**Our Ref: AB/61/17/HH**  
**Your Ref:**

**Town & Country Planning Act 1990 (as amended)**  
**Town & country Planning (Development Management Procedure) (England) Order 2015**  
**Application for Planning Permission for Works or Extension to a Dwelling**

**Development** First floor rear extension.  
**Location** Mallards 8 Fitzalan Road Arundel

8 Fitzalan Road

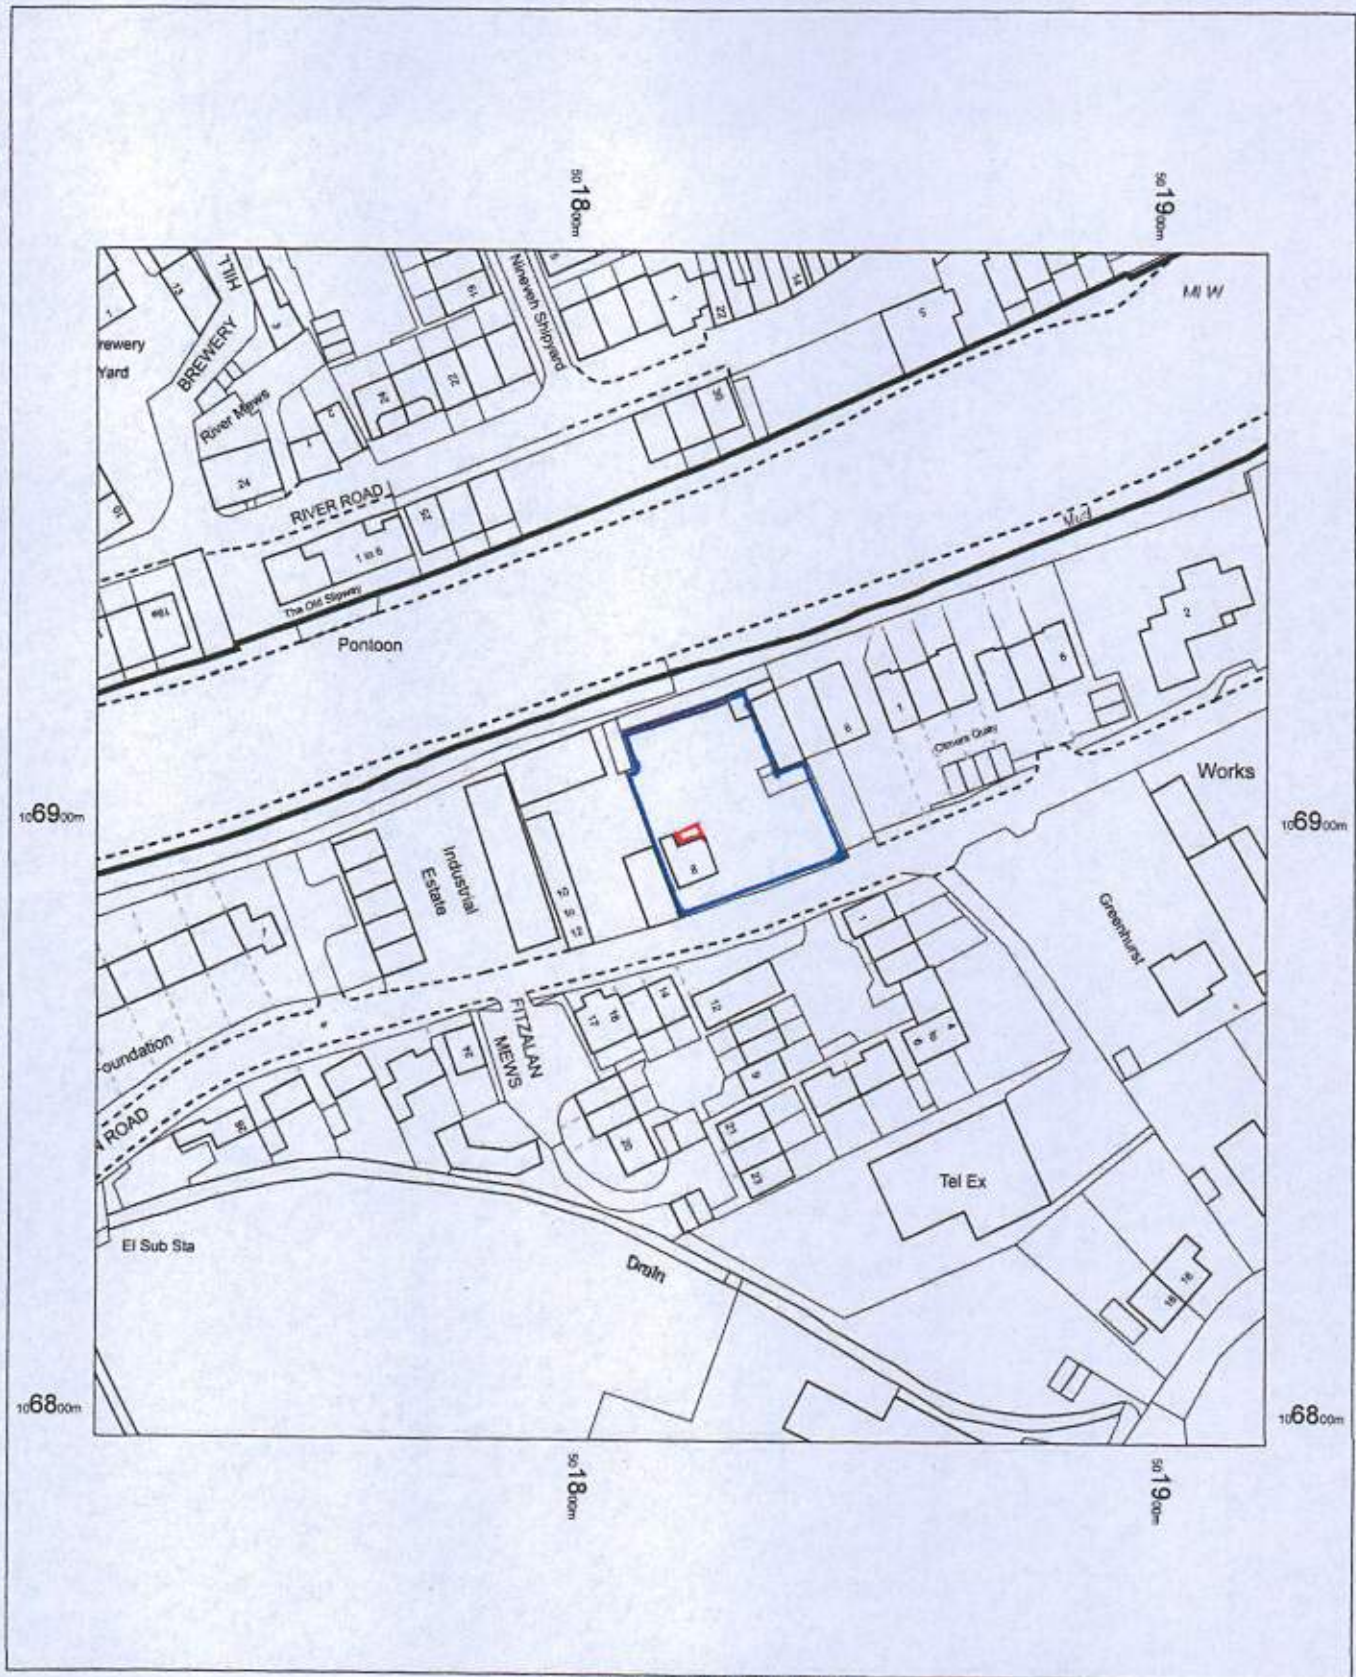
The location plan, block plan, floor plans and elevations do not scale correctly. Please amend accordingly.
